The Sizewell C Project, Ref. EN010012

Issue Specific Hearing 7 (15 & 16 July 2021) – (ISH7) Biodiversity and Ecology

Post Hearing Submissions including written summary of Suffolk County Council's Oral Case

Suffolk County Council Registration ID Number: 20026012

DRAWING TITLE:
MAIN DEVELOPMENT SITE
SSSI CROSSING (SZC OPERATIONAL)

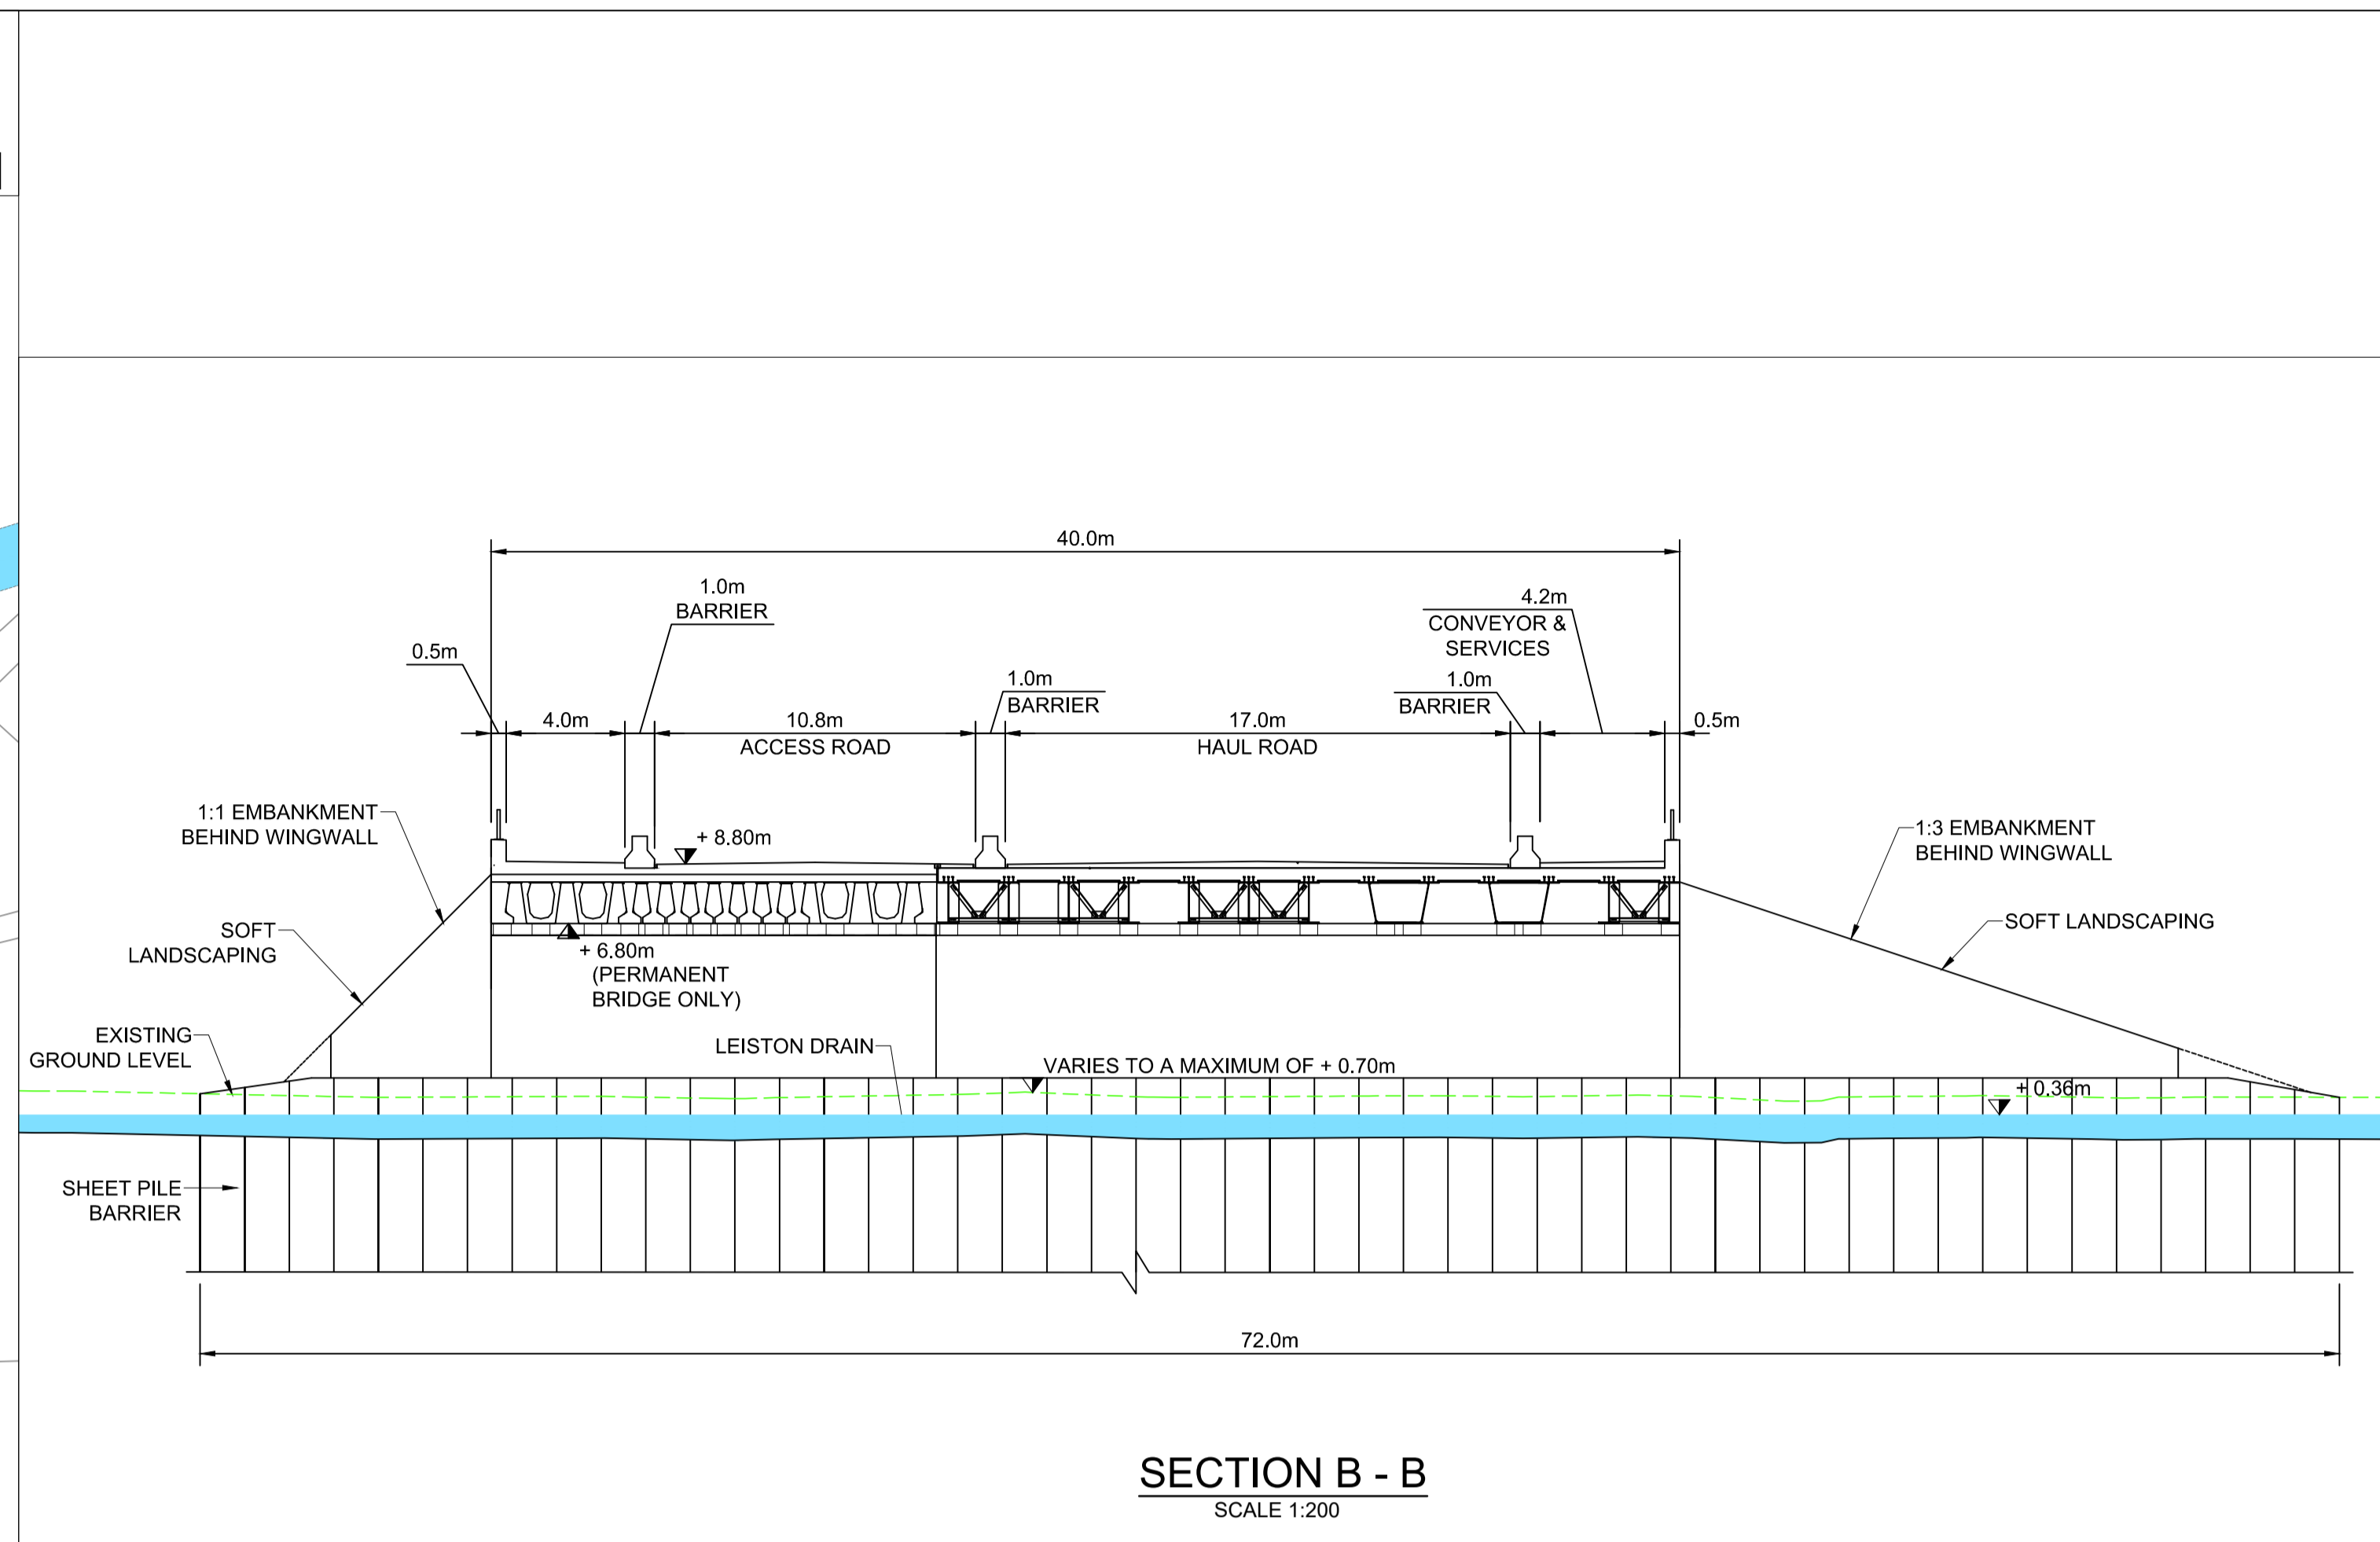
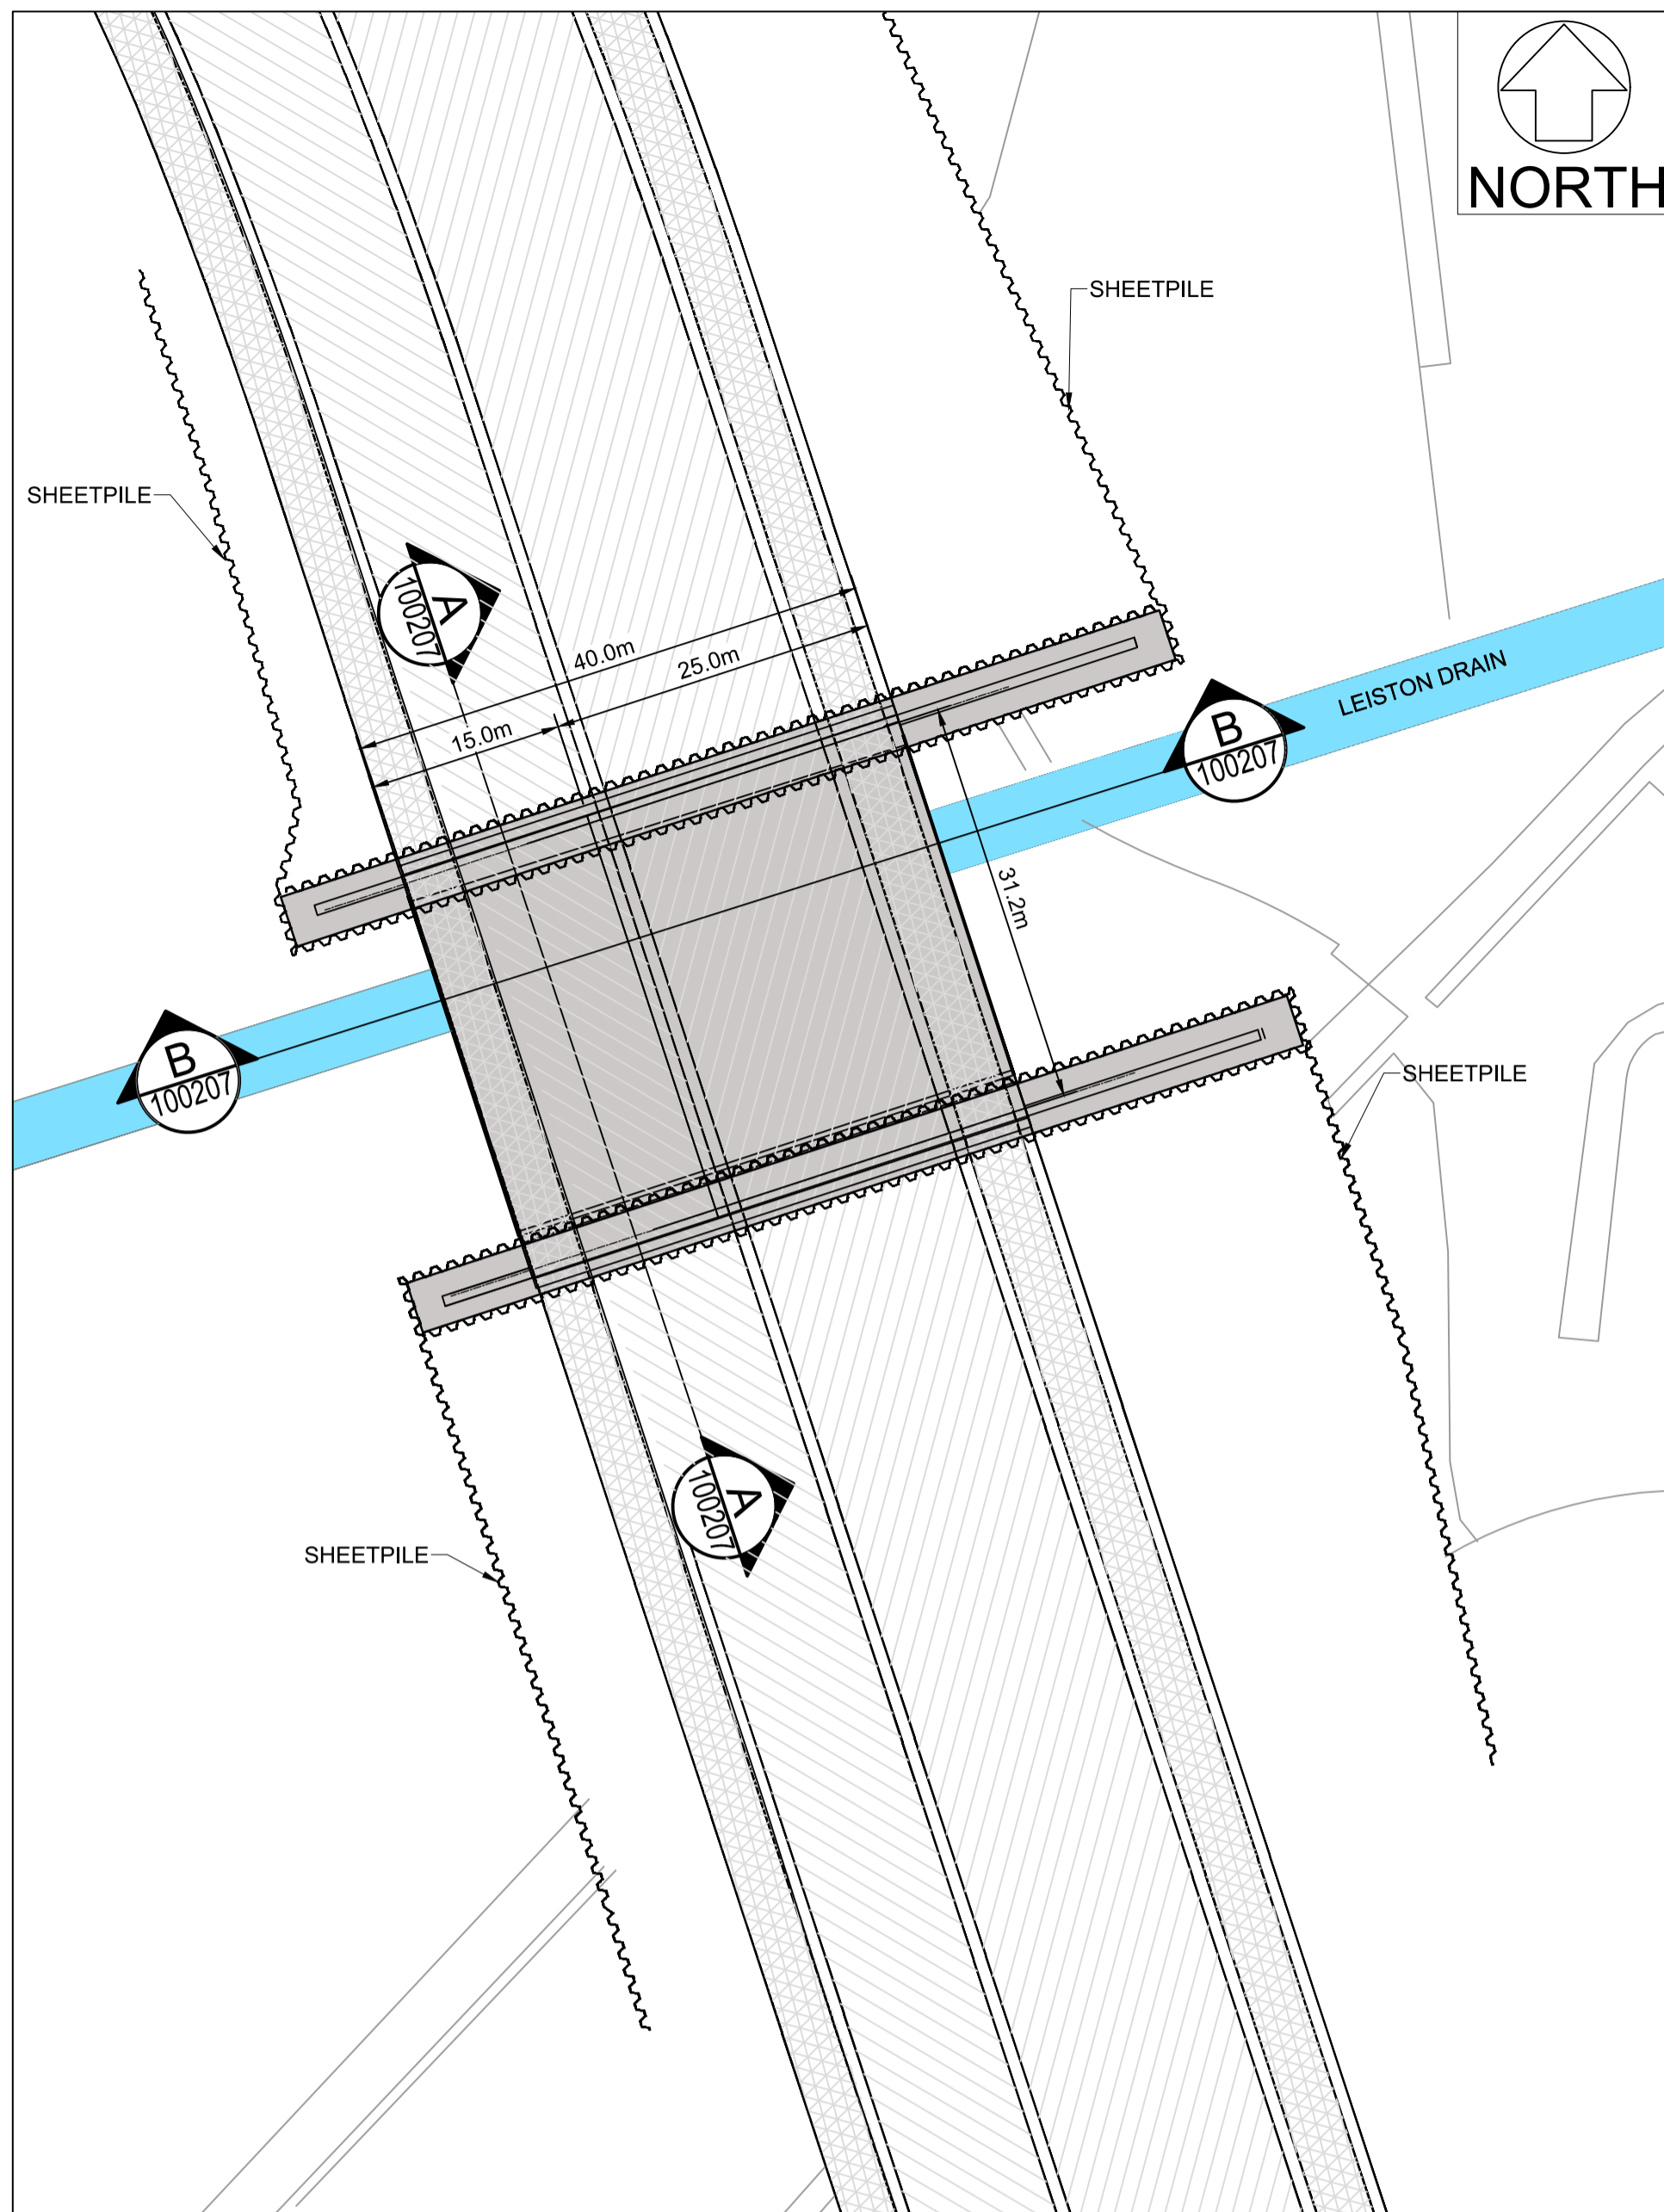
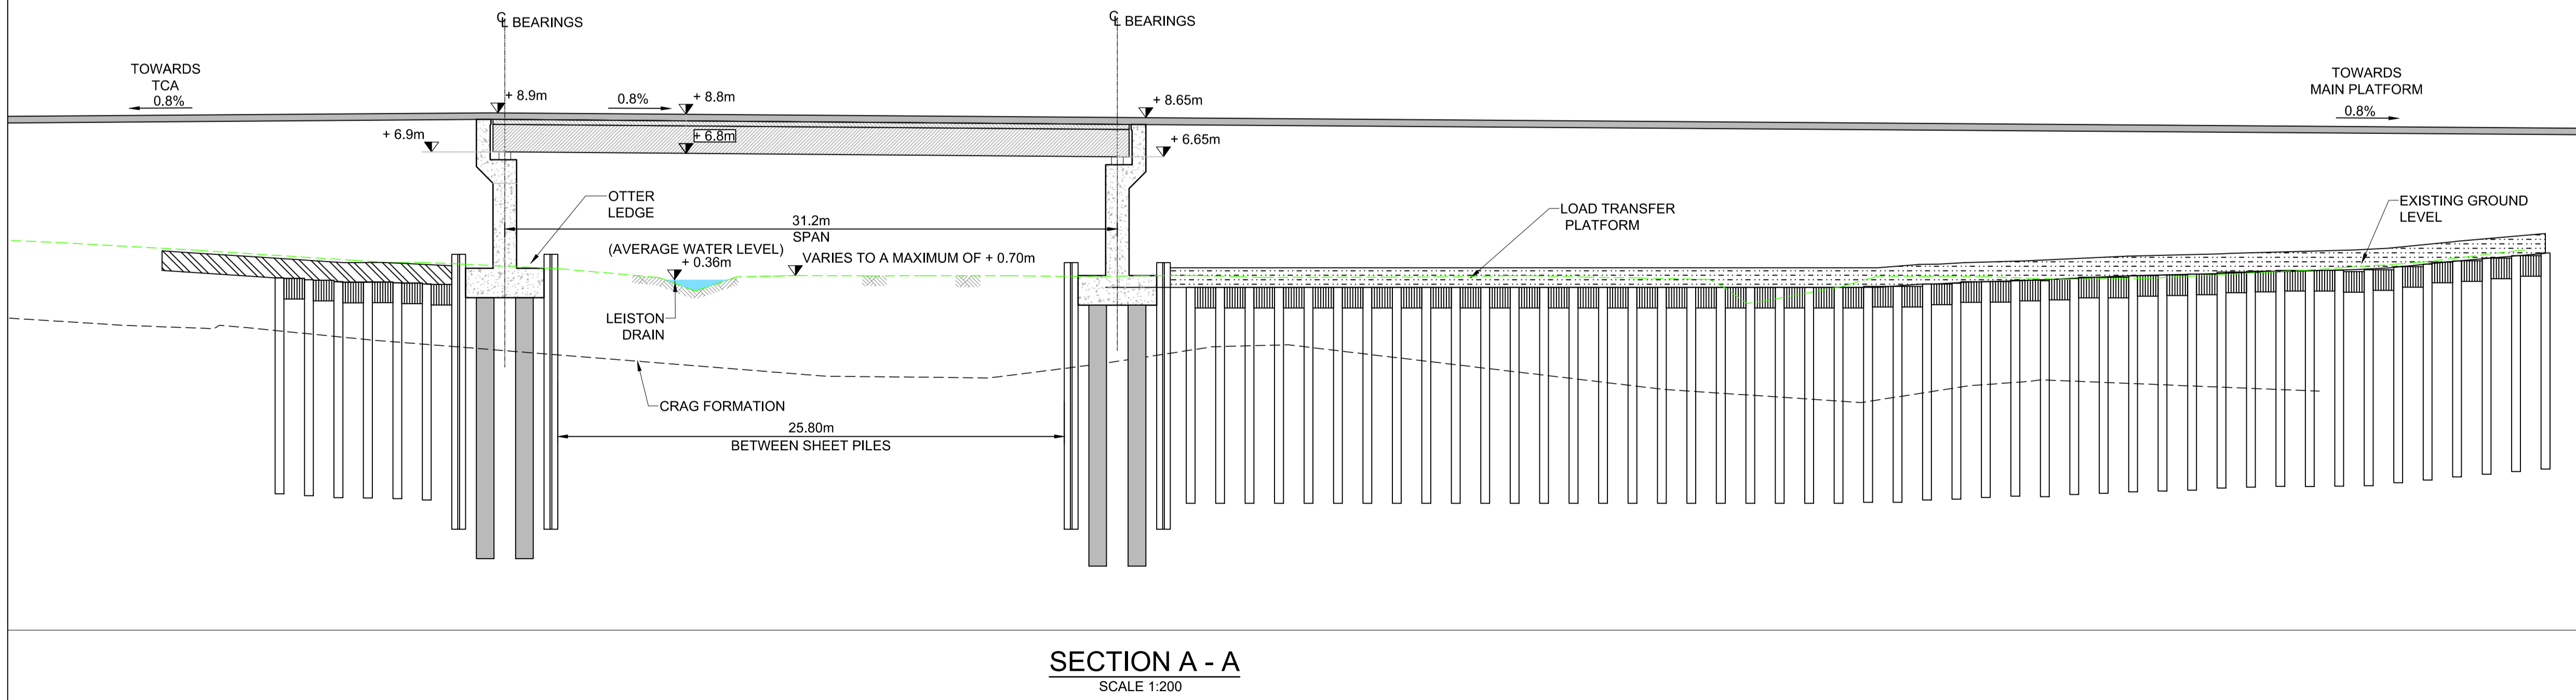
<p>i. the SSSI crossing,</p>	<p>SCC has a preference for a three-span bridge rather than a causeway in first instance. The national policy position for impact on SSSIs is that impacts should be minimised.</p> <p>EN-1, at paragraph 4.4.2, sets out that the policy for consideration of alternatives is provided in section 5.3. Paragraph 5.3.7 sets out the general principle that significant harm to biodiversity should be avoided through mitigation and consideration of reasonable alternatives. Paragraph 5.3.11 sets out a presumption of refusal with regard to proposals with adverse impacts on SSSIs, while providing an exception for cases where the benefits clearly outweigh impacts on special features.</p> <p>Further, EN-6 volume II paragraph C.8.65 makes clear that the balance of impact on the SSSI is a matter for project-level assessment while paragraph C.8.63 requires the applicant to develop an ecological mitigation and management plan to minimise impacts.</p> <p>In its oral submissions at ISH7 the Applicant suggested (in response to questions from the ExA) that the SSSI crossing could not be constructed at any earlier stage in order to offset the 6-12 month time difference between construction of the Applicant's causeway/culvert option and the three-span bridge option preferred by SCC (and NE and others). The Applicant proposed to put in a note at D6 to explain its position on whether the crossing could be constructed 'at risk' once a DCO had been made, and SCC will comment when such a note becomes available.</p> <p>The applicant has represented in its comments to our written representations [REP3-042] that there would be a very small difference in permanent land take between the current proposal and a three span bridge. At our oral submission we asked</p>

<p>whether the applicant could demonstrate this by providing a comparative plan which overlays the two proposals and shows the boundaries of the SSSI. We also asked for clarification as to whether the temporary construction land take utilised additional land within the SSSI and asked for this to be identified.</p> <p>We note that during the Stage 2 consultation process, as shown in [APP-072], the difference between the SSSI land take of the two options (i.e. option one and option three) in the construction phase is much larger at around one third of a hectare (see Tables 7.2 and 7.3 and Figures 7.21 to 7.24). Noting that option one has been superseded by the present causeway proposal, we would like the applicant to provide a similar comparison between option three and the present causeway.</p> <p>A fair comparison should also show the improvements to the present causeway design applied to the three-span bridge such as the removal of a 15-meter wide strip of the crossing deck.</p> <p>SCC notes from the Applicants response to ExQ Bio 1.47 the Applicant's intention to reduce the width of the bridge to approximately 15m once the power station has been built and their intention to submit updated indicative plans and further details at Deadline 5. SCC will review this once it has been provided by the Applicant to consider the extent to which it addresses the concerns that we raised on the proposed SSSI crossing design in our Local Impact Report at [REP1-045]. Whilst a reduction in the width of the permanent crossing is – on the face of it – a welcome positive step, we remain concerned about the impact of the much wider proposed temporary crossing on the SSSI and ecological connectivity whilst it is in place.</p>
